From: Anita Gardner
Sent: 07 September 2017 13:00
To: Planning.Responses
Subject: FW: A/112/17/CLP - Lawful Development certificate for single storey side and rear extension and loft conversion 11 Roman Avenue

Subject: Re: A/112/17/CLP - Lawful Development certificate for single storey side and rear extension and loft conversion 11 Roman Avenue

PL001

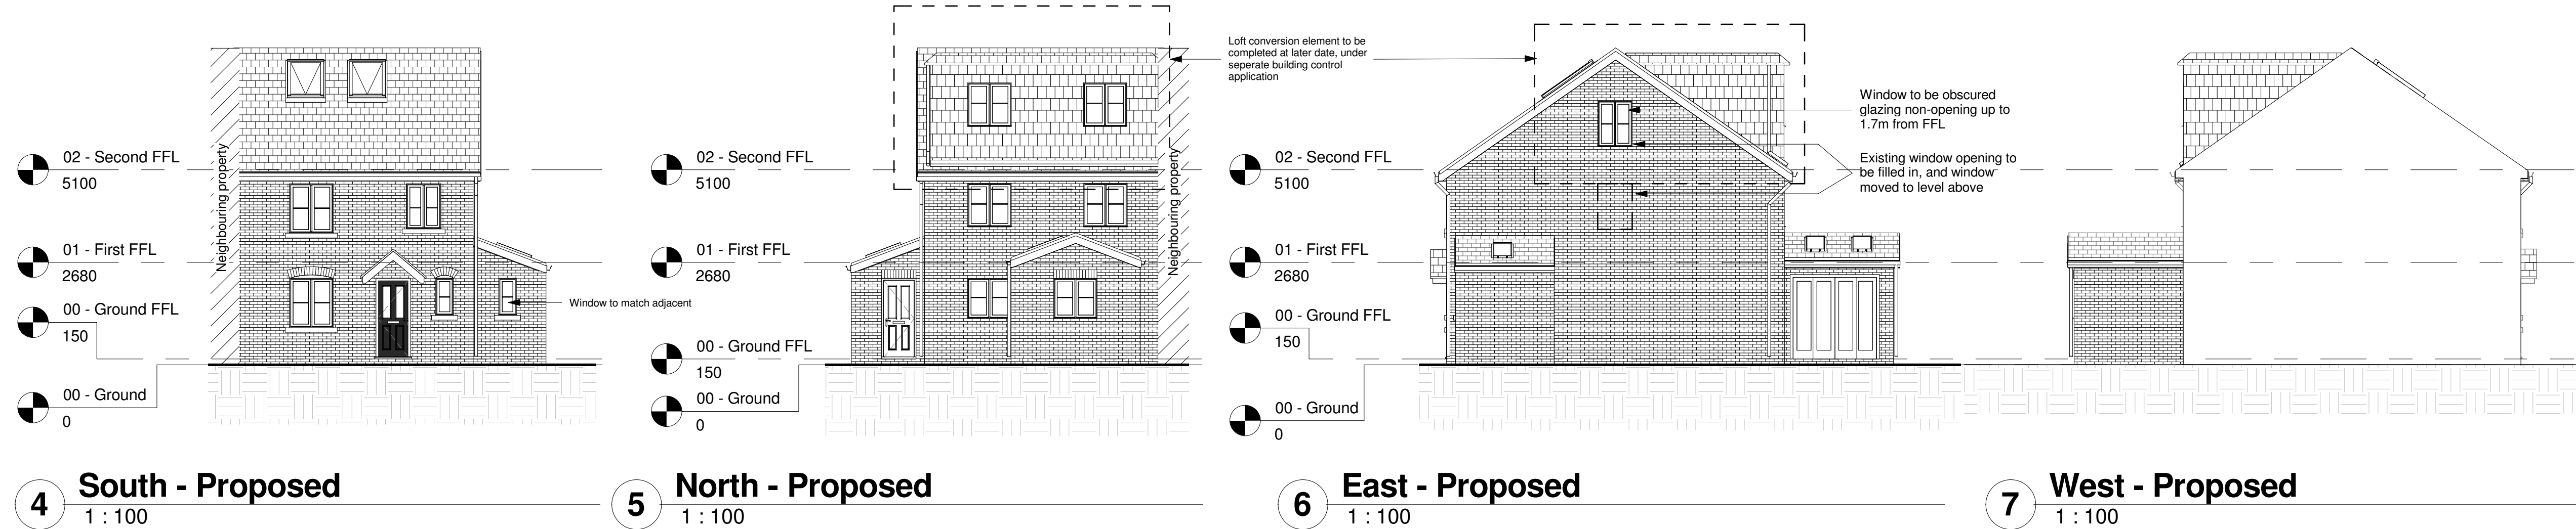
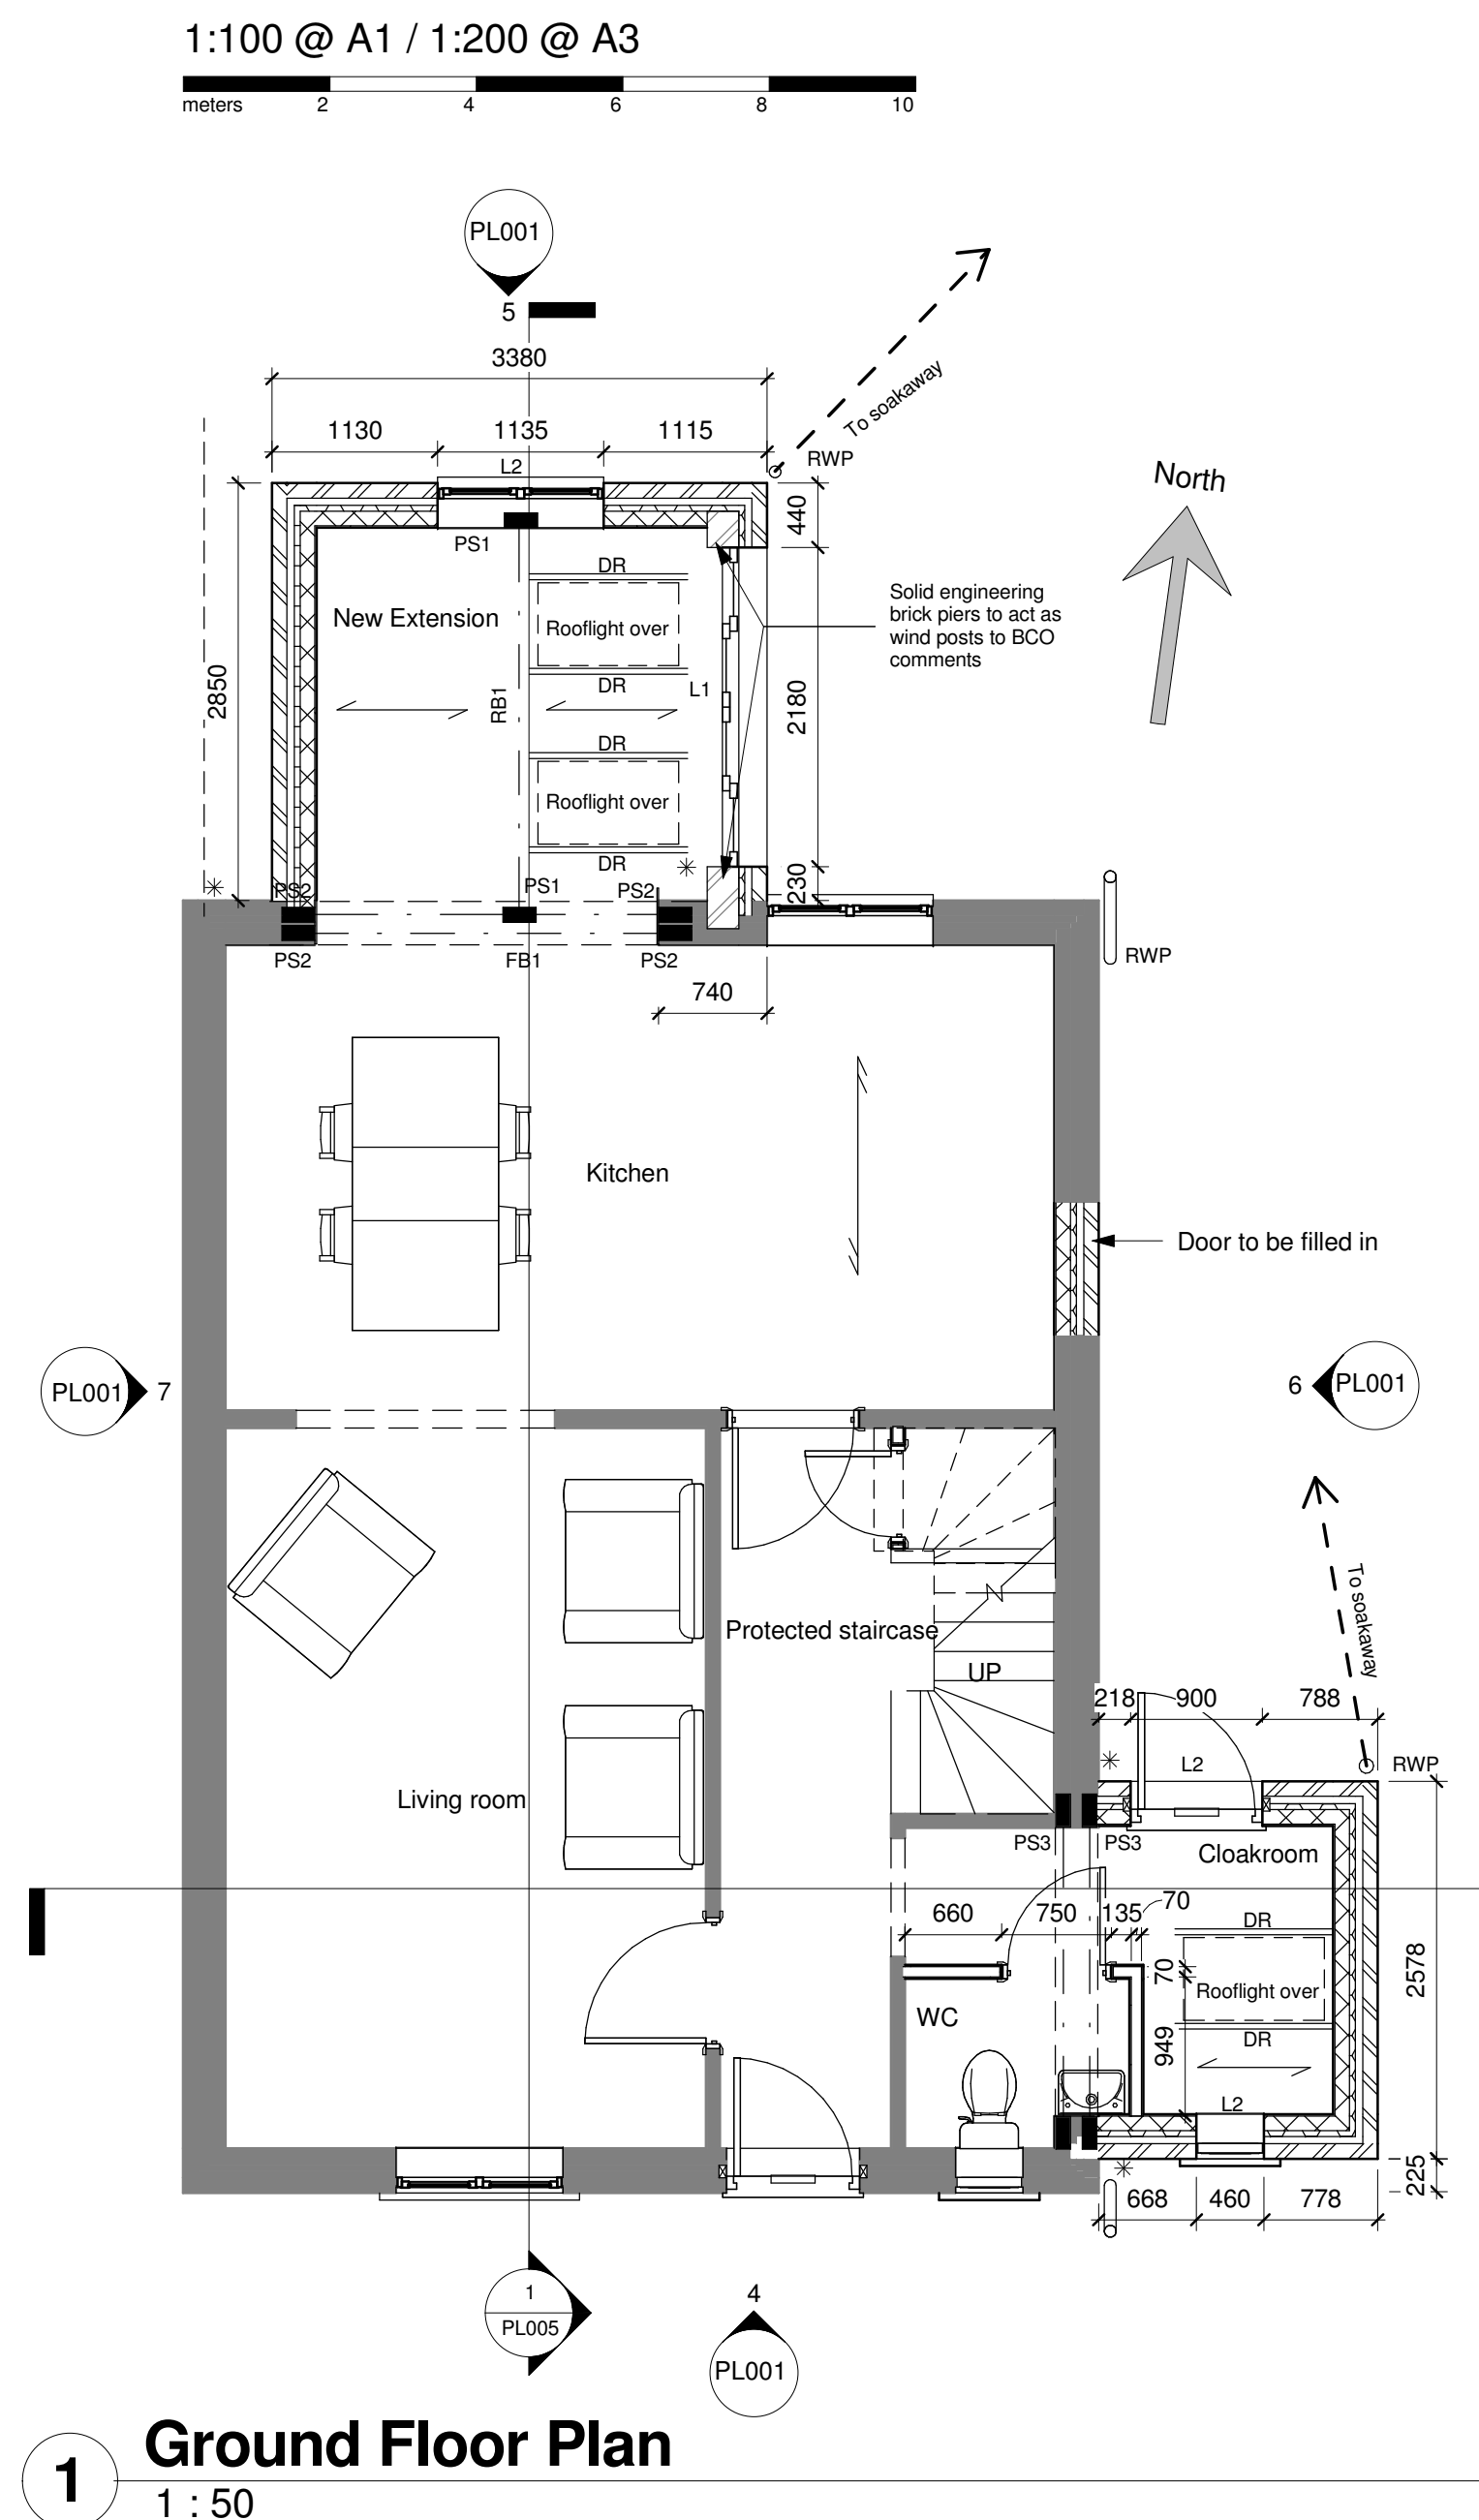
Can I just double check you mean the new window added recently to the elevation fronting the highway on the side extension?

I refer to the above application and can advise that for the proposed window in the side elevation to be considered permitted development it must be obscure glazed and non-opening below 1.7m. There is no note to this effect on the plan and I would appreciate your confirmation accordingly

There was a note there originally, it must have been deleted when updating. Yes this window will be obscured non opening as mentioned.
